# Defence Infrastructure Organisation

## **MOD Safeguarding – Warton Aerodrome**

**Proposal:** Application by Morgan Offshore Wind Limited and Morecambe Offshore Windfarm Limited for an Order Granting Development Consent for the Morgan and Morecambe Offshore Wind Farms Transmission Assets: Transmission assets associated with the Morgan Offshore Wind Project and the Morecambe Offshore Windfarm including: offshore export cables, onshore landfall infrastructure, onshore export cables, onshore substations, onshore grid connection cables and circuit breaker compounds, and other related onshore infrastructure

**Location:** From Morgan and Morecambe arrays to Penwortham Substation outside of Preston (landfall at Crusader Bank between Blackpool and Lytham St Anne's)

Figure 1.4: Indicative areas of habitat creation and enhancement at the Morgan onshore substation

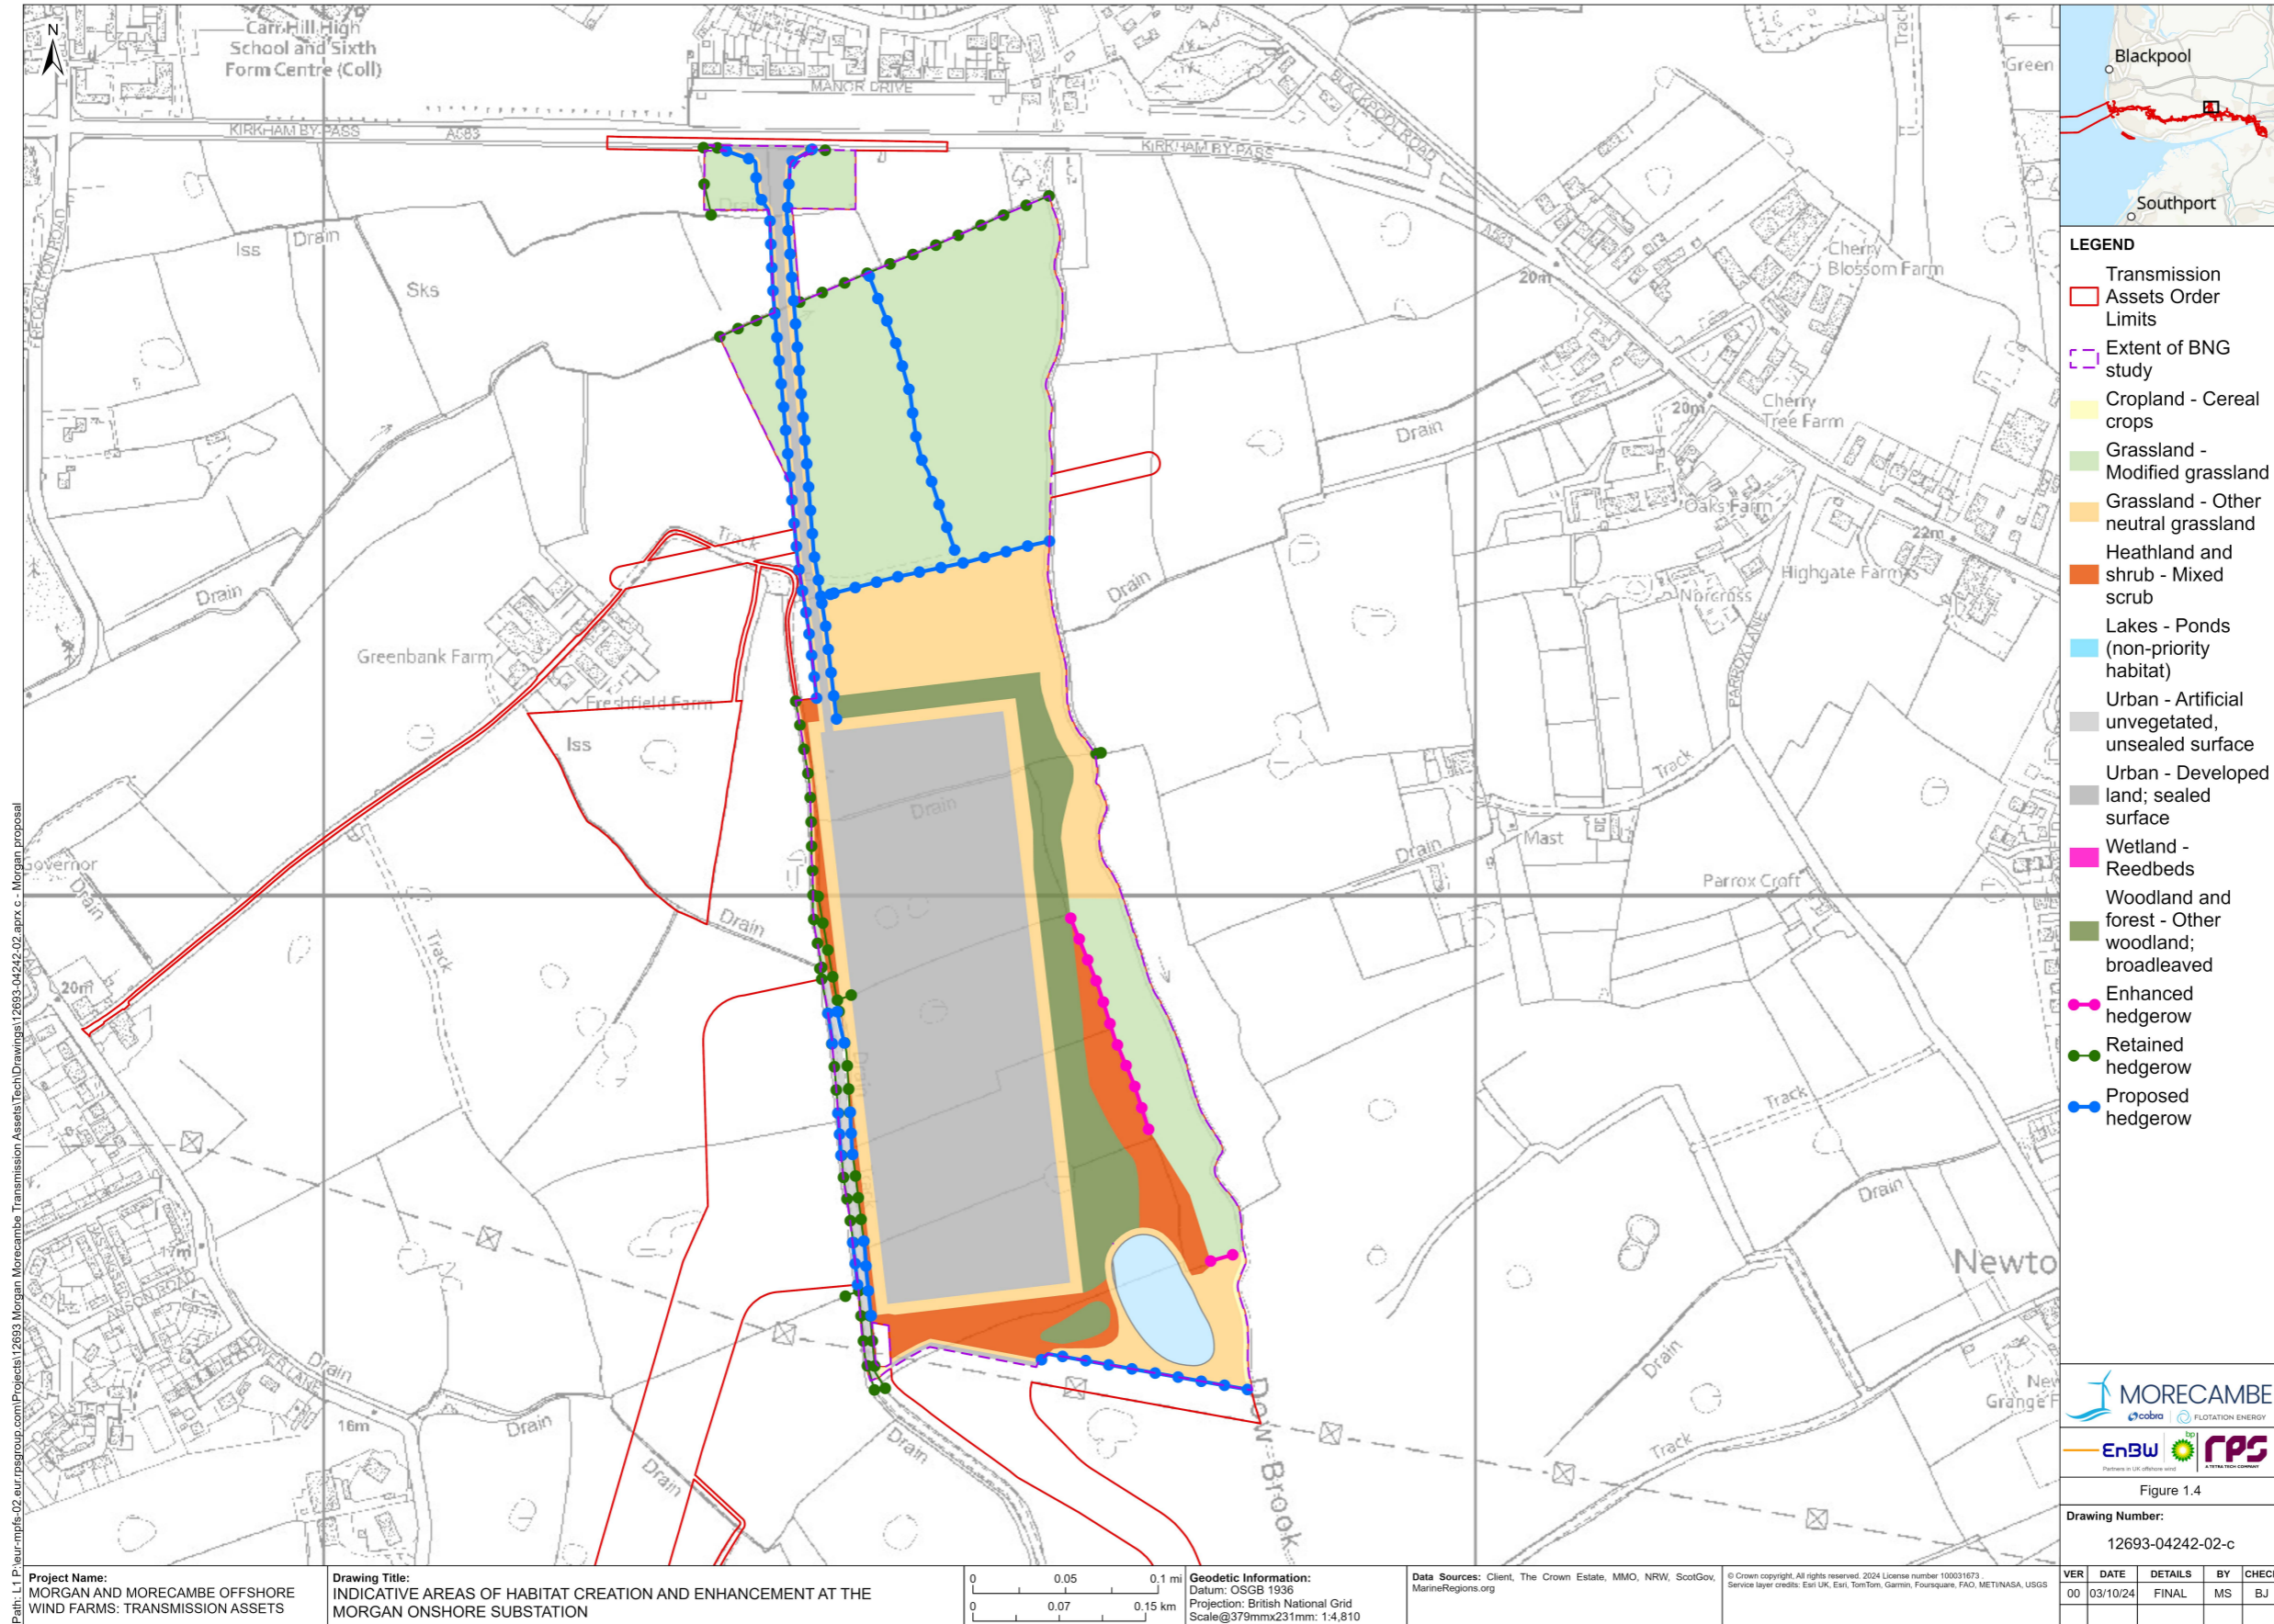
The applicant's submission identifies that, close to each of the two proposed new onshore substations, new waterbodies are to be created which would replace a number of existing smaller ponds. The waterbody proposed close to the Morgan onshore substation would result in the creation of a significantly larger area of open water which would be more attractive to both waterfowl and gulls than the existing smaller waterbodies. This larger waterbody has the potential to attract large and/or flocking bird species from the River Ribble and the Ribble Estuary which may result in the movement of birds across the aerodrome as well as through airspace where aircraft from take-off and/or to land at Warton Aerodrome. The creation of such a waterbody close to the aerodrome would, without the provision of details necessary to assess the potential to form an attractant (specifically relating to the form, operation, and maintenance of the waterbody), be considered unacceptable. Given the proximity of the development corridor to Warton Aerodrome and the potential for the development to result in the degradation of aviation safety the MOD must, at this time, **object** to the proposal.

Across the wider development corridor hedgerow, scrub, and woodland planting are proposed. Extensive planting of species with high proportions of fruit, berry, and hip bearing plants may result in a significant increase in availability of these food sources for hazardous flocking birds, including Starlings, winter thrushes and Wood Pigeon. In addition, the management of soil as may be produced through the installation of cables has the capacity to provide a food source for hazardous flocking bird species. The proximity of these potential food sources/feeding habitat to Warton Aerodrome have the potential to attract hazardous bird flocking species resulting in the detriment of aviation safety.

- specifics for each of the proposed waterbodies to include location and site plans, section plans which clearly show bank profile and water level (taking into account 1:30 and 1:100 storm events);
- where waterbodies are designed to drain to dry, details of the drain to dry time given storm events (1:30 and 1:100); and
- proposed maintenance measures and schedules to ensure any designed drain to dry time does not increase.
